**Town & Country Planning Act 1990 (as amended)
Town and Country Planning (Development Management Procedure) (England) Order 2015
Application for Planning Permission**

Development Demolition of existing bowls pavillion & replacement with new bowls pavillion, ground floor alterations & first floor extension to existing gym facilities to include DDA provisions. This application may affect the setting of a listed building.

Location Middleton Sports Club 3 Sea Lane Middleton on Sea

DRAWING
PROPOSED
BOWLS CLUB PLAN
DRAWING No
296/03
SCALE
1:100
DATE
11 MAY 2019
REVISION
DRAWN
CHECKED
LA

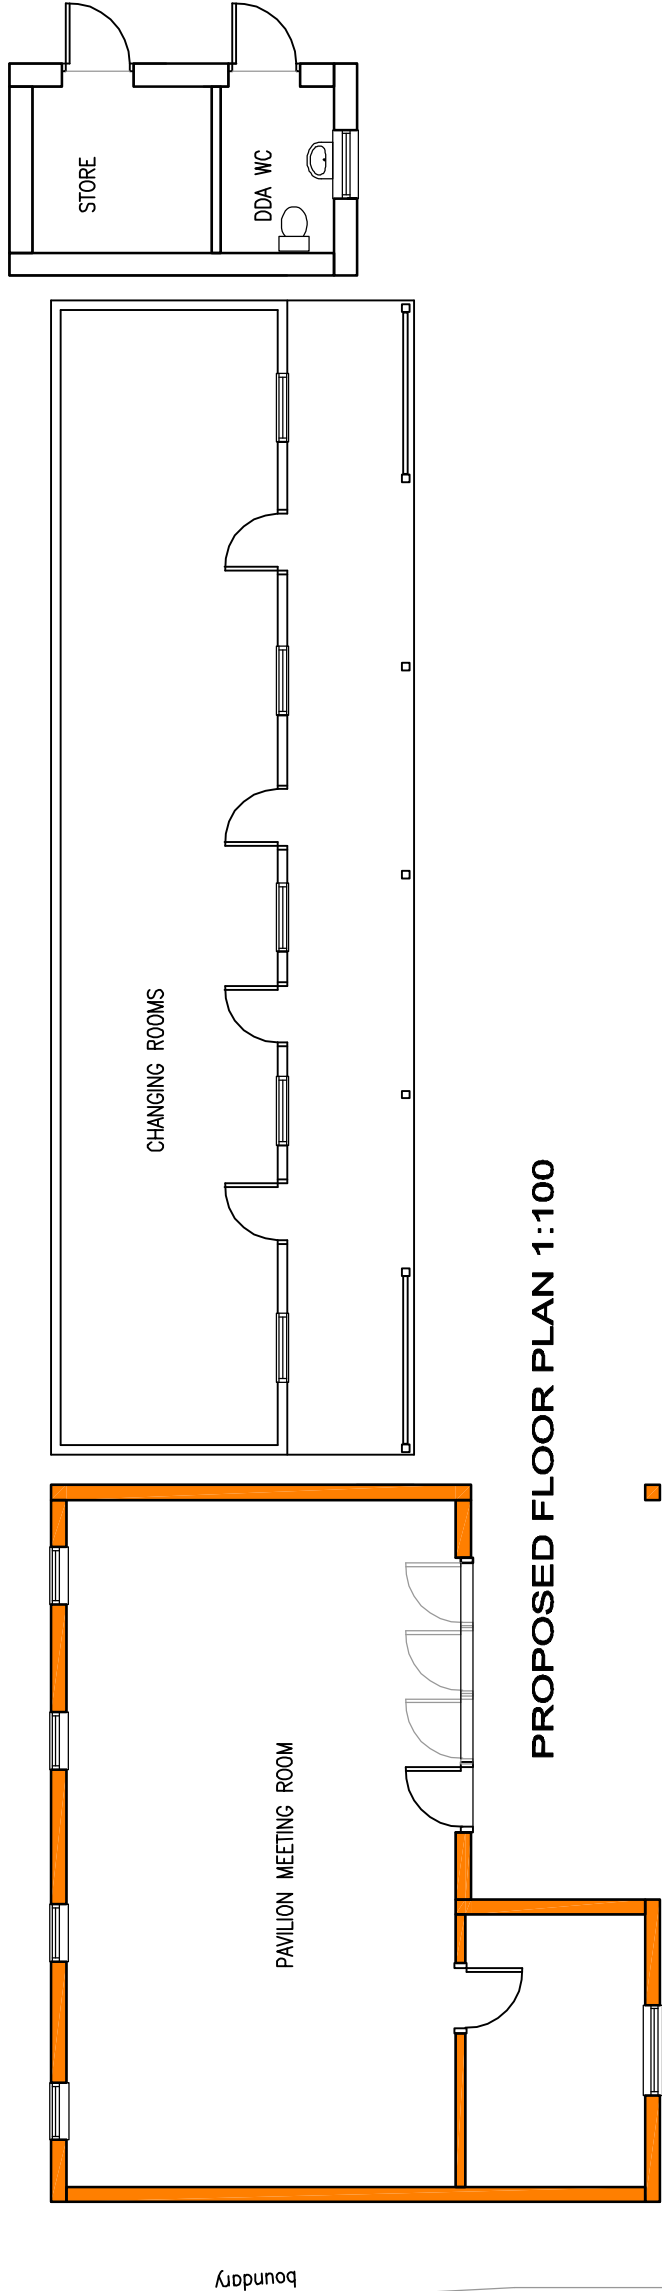
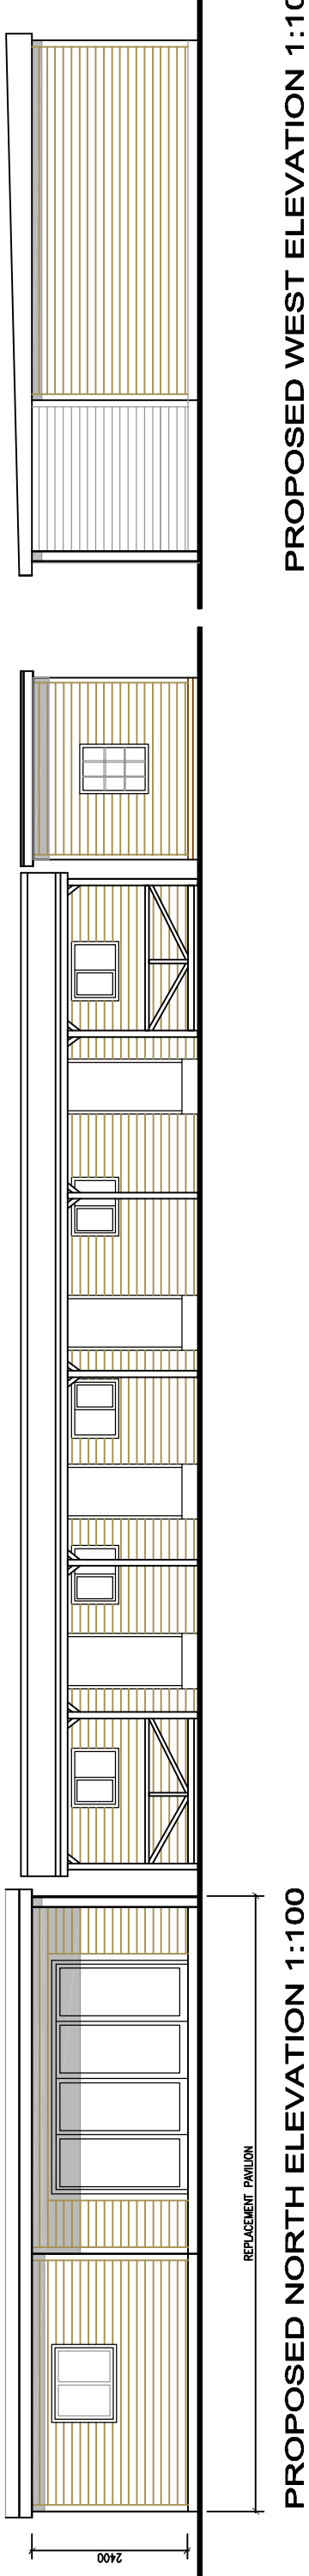
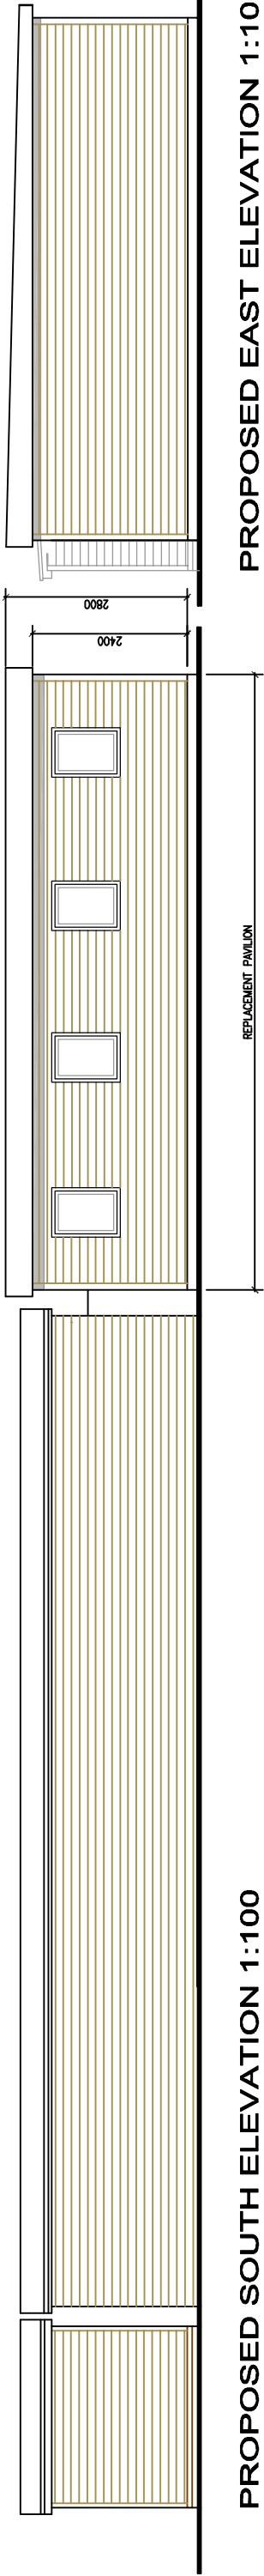
On the proposed pavillion, the proposed west floor plan and elevation do not accord. Please amend accordingly.

PART PROPOSED GROUND FLOOR PLAN 1:100

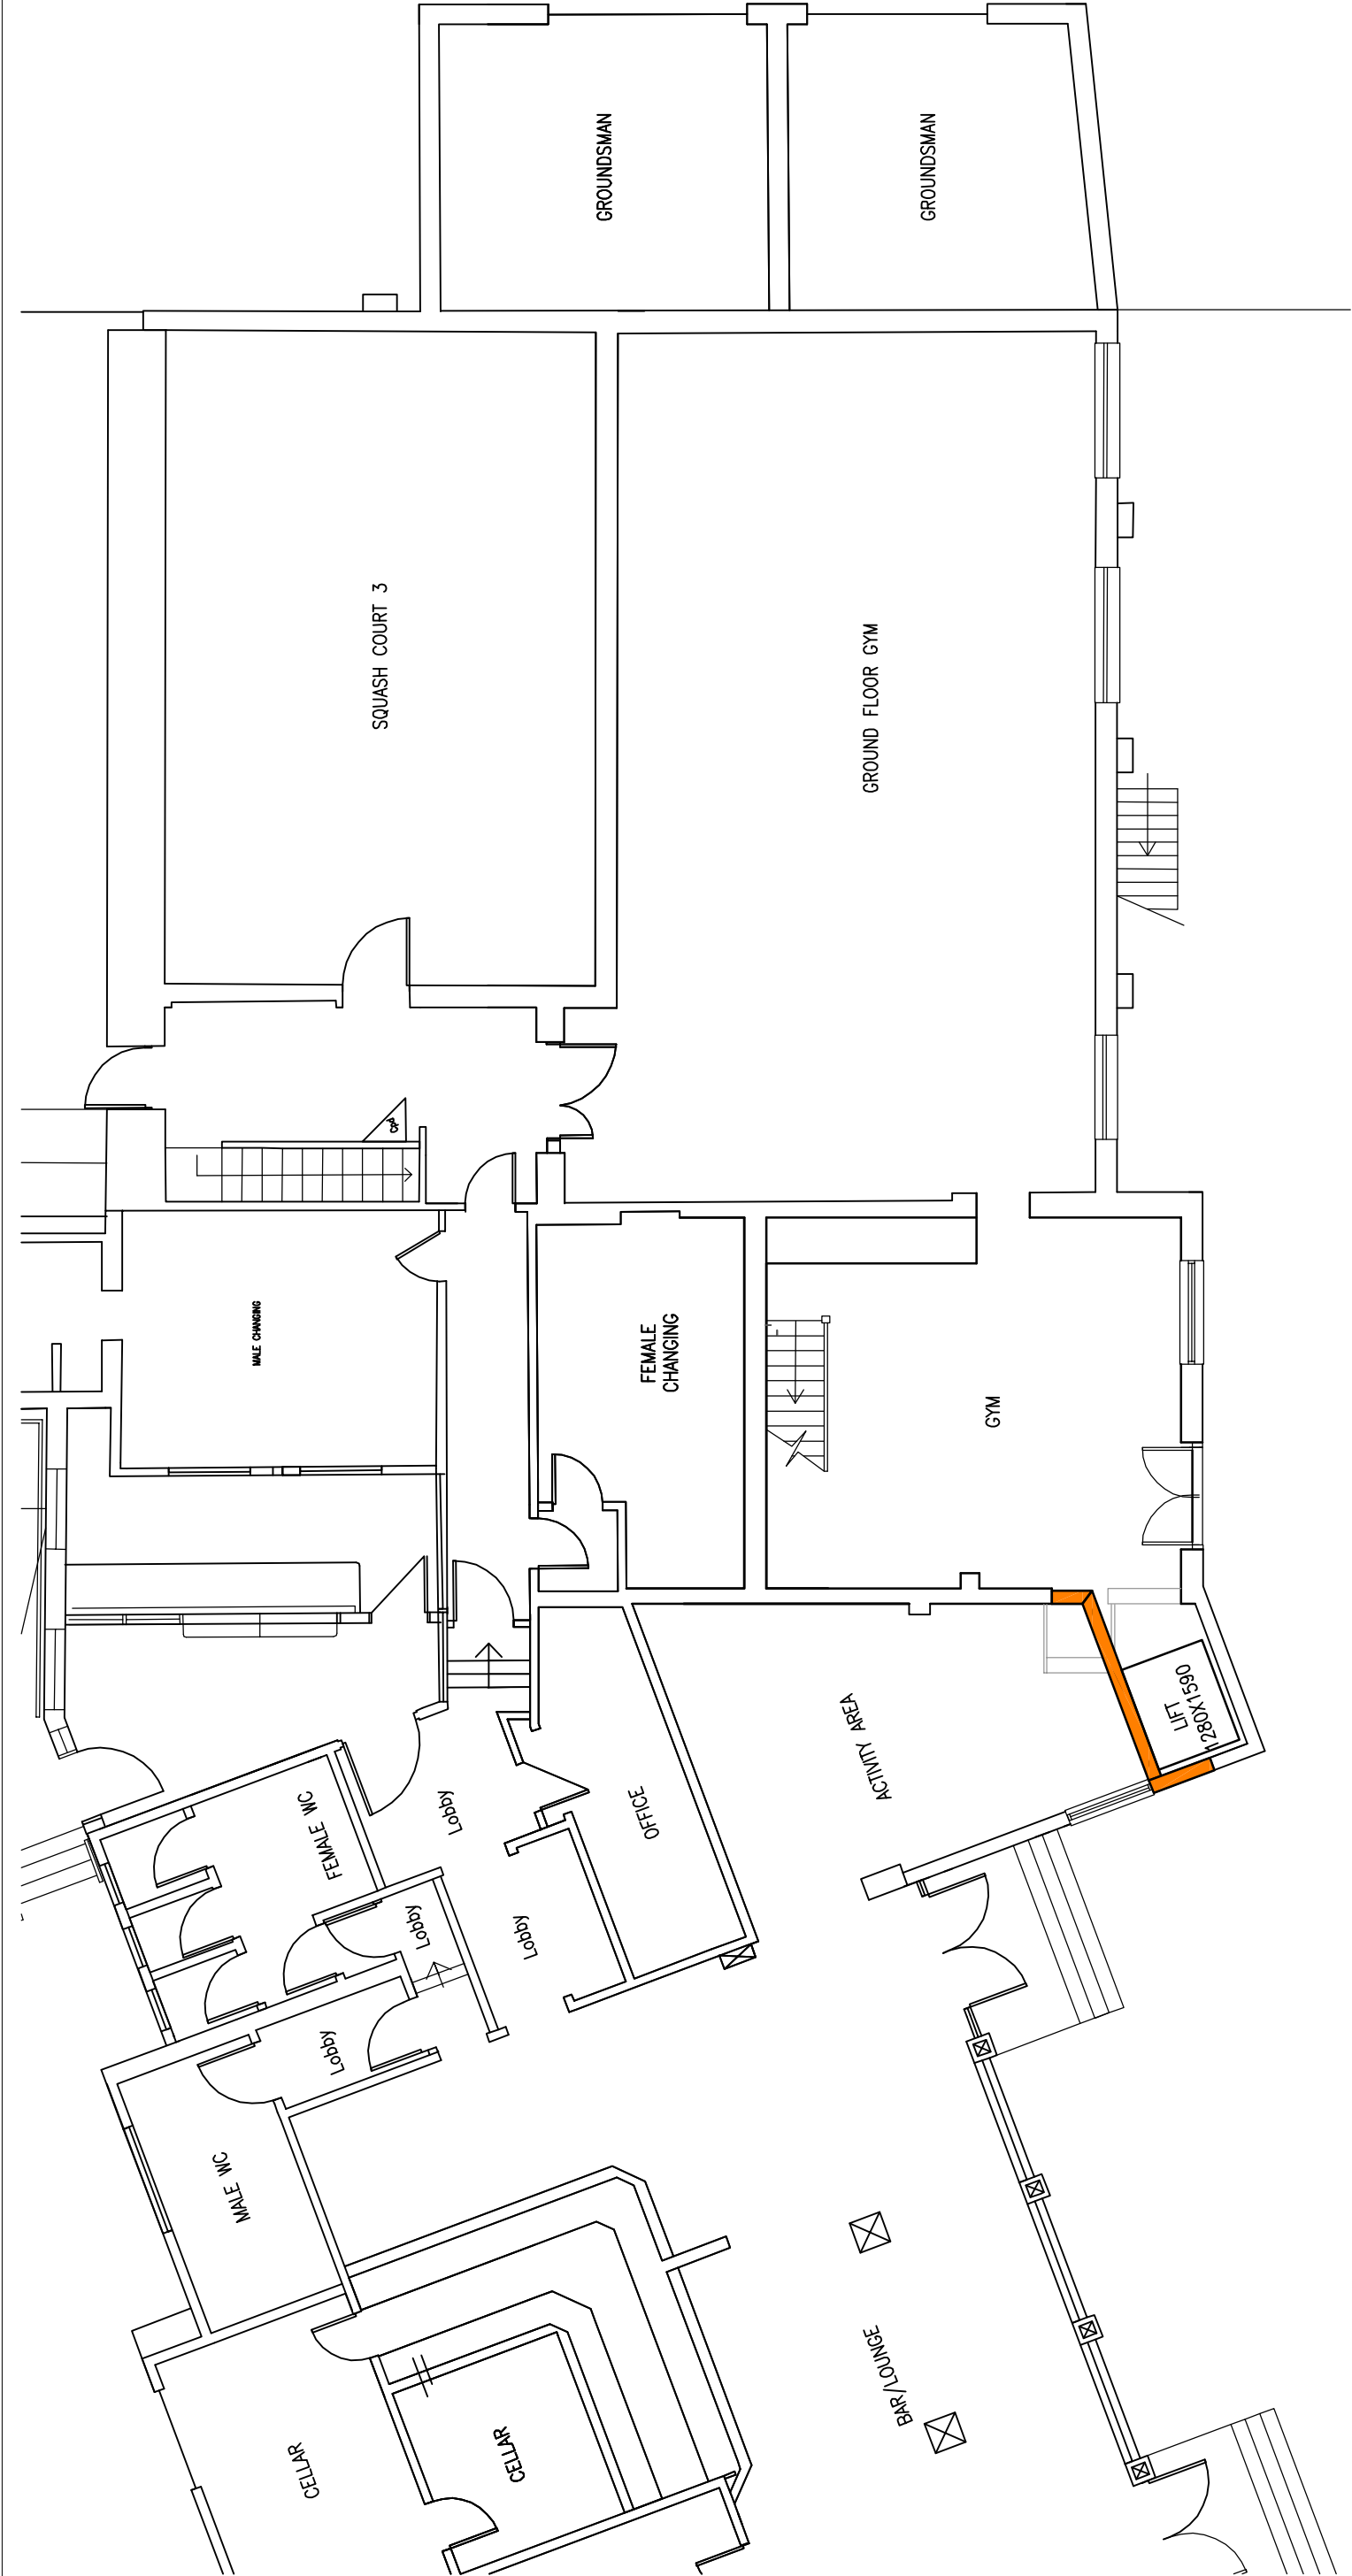
1. The existing south elevaiton and ground floor plan do not accord and the windows on the ground floor gym do not scale correctly.
2. The existing south elevation and first floor plan do not accord.
3. The proposed south elevation and ground floor plan do not accord and the windows on the ground floor gym do not scale correctly.
4. The proposed south elevation aand first floor plan do not accord.
5. The exisitng east elevation and first floor plan do not accord.
6. The proposed east elevation and first floor plan do not accord.
